Our reference: P-666379-Y7M3  
Contact: Sandra Fagan  
Telephone: (02) 4732 7992

24 April 2024

**Council Response to Environmental Impact Statement – SSD-23480429  
– Westgate at 253-267 Mamre Road, Kemps Creek, NSW, 2178**

Figure 37 – Warehouse 1B/1C – Undercroft Car Park Plan

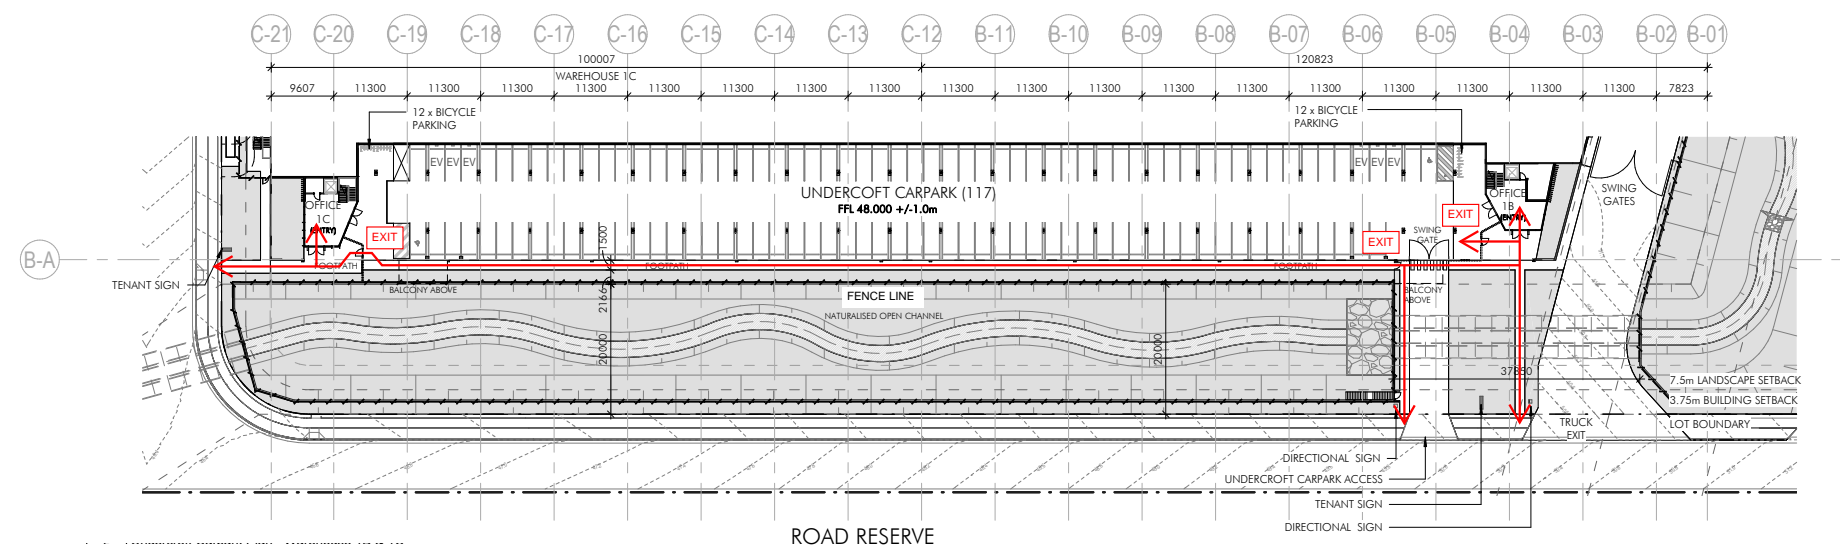
- l) The extensive use of under-croft car parking as a design solution will negatively impact opportunities for better landscaping within the car parking hardstand areas, such as providing canopy trees. Canopy trees in hardstand parking areas can be successfully used to moderate bulk, scale, and visual appearance of buildings. However, this cannot be done in this instance given the extensive use of under-croft parking for every warehouse. The use of under-croft parking also adds bulk to the warehouse as the warehouse floor level is raised. There is also limited space available between the under-croft parking area for warehouses 1B and 1C, and the adjoining retaining wall along the drainage channel.

Figure 43 - Landscape Plan (Trunk Drainage Channel) [Source: Scape Design]

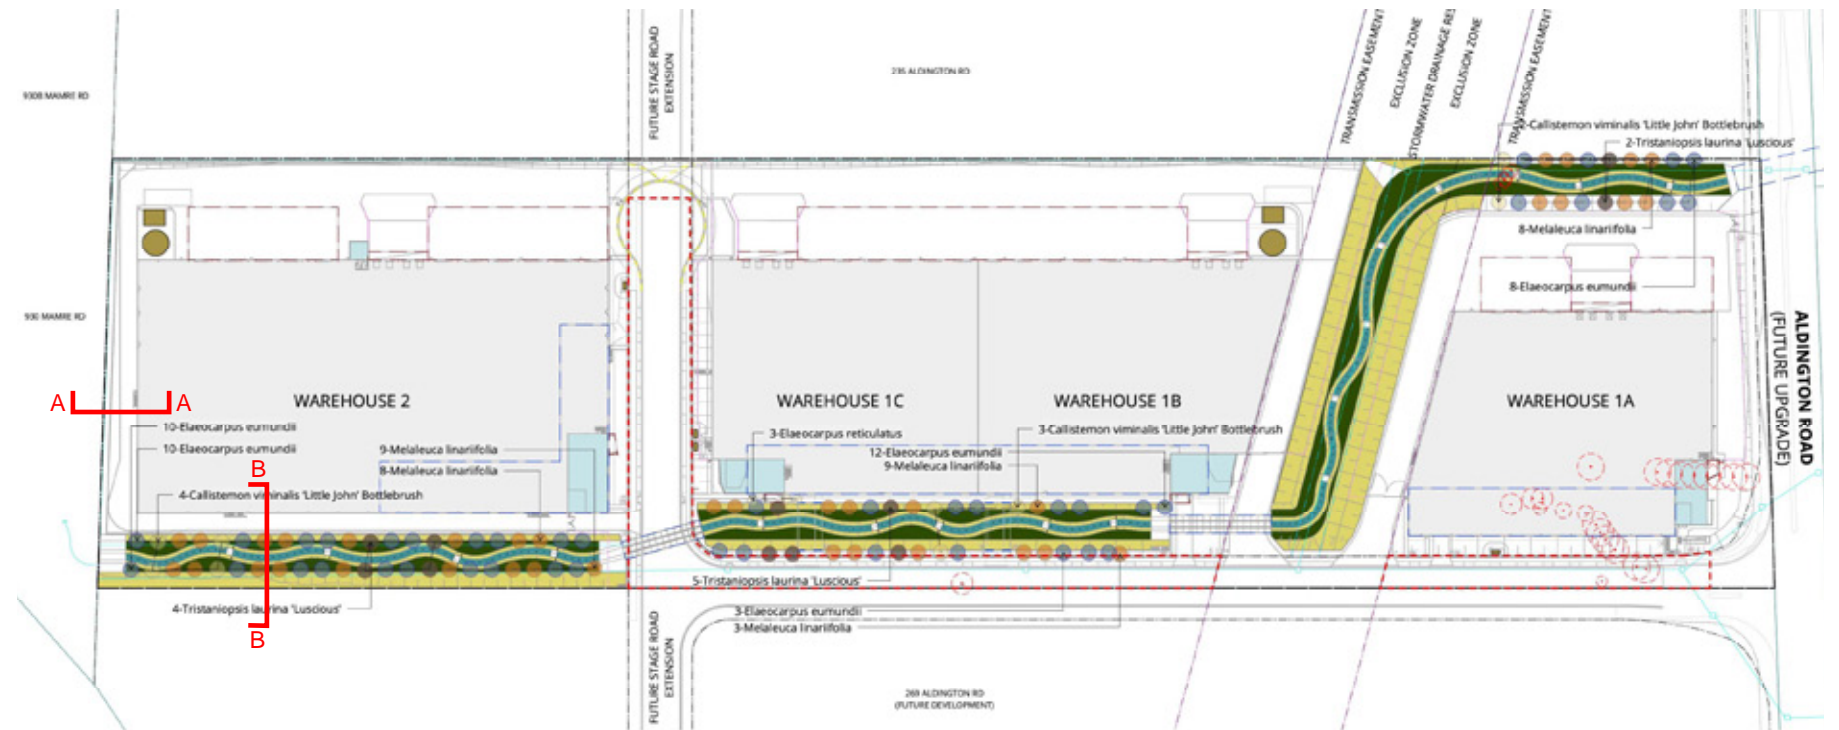
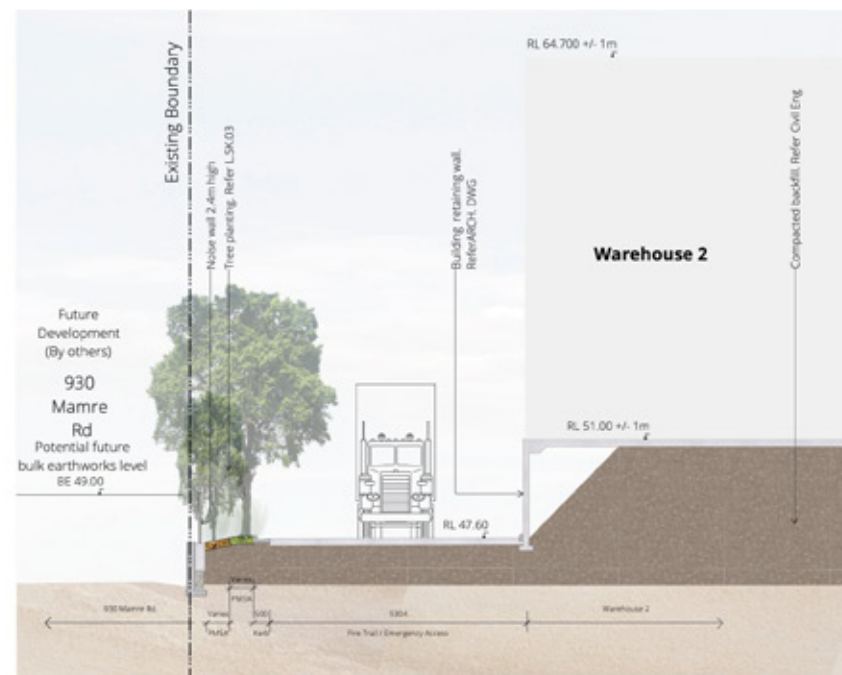
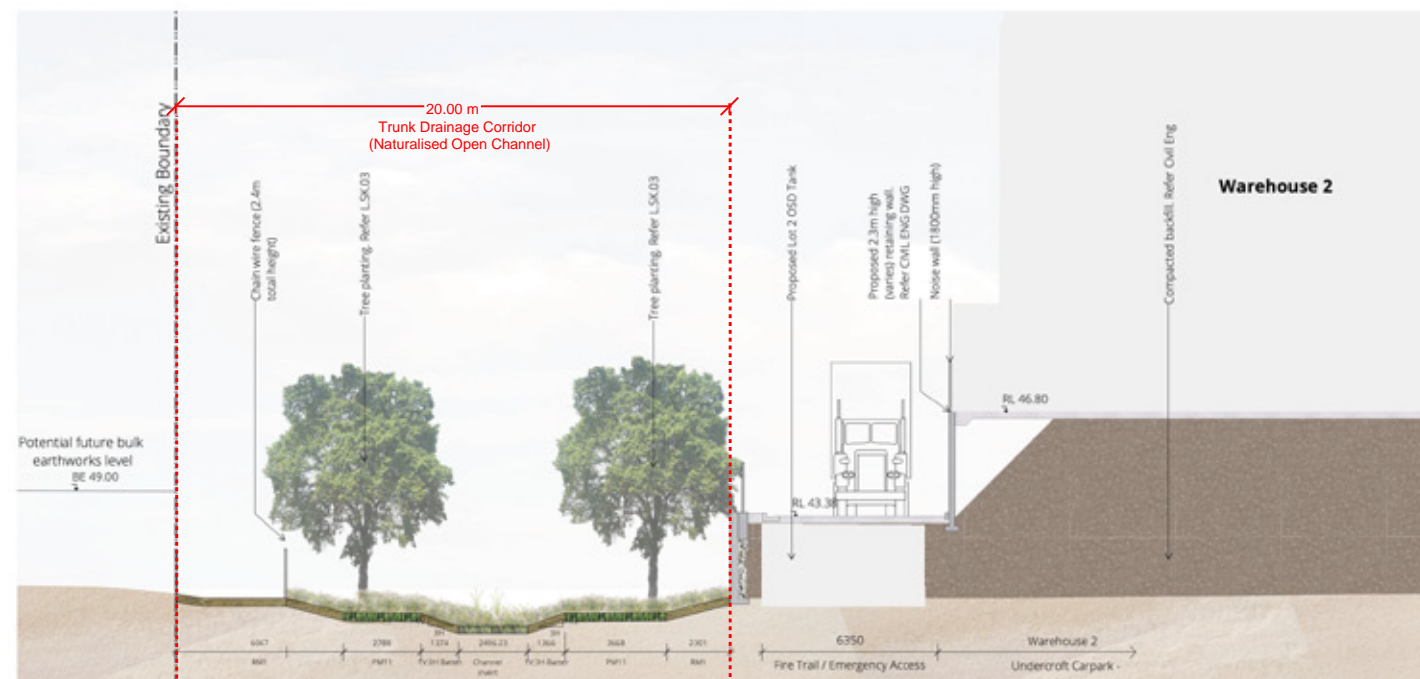
- j) The proposed retaining wall at one side of the trunk drainage channel is high and is not tiered. This is likely to have a negative visual impact, particularly given the significantly raised level of the warehouses, and the restricted ability to provide for tall trees within and adjoining the drainage channel.
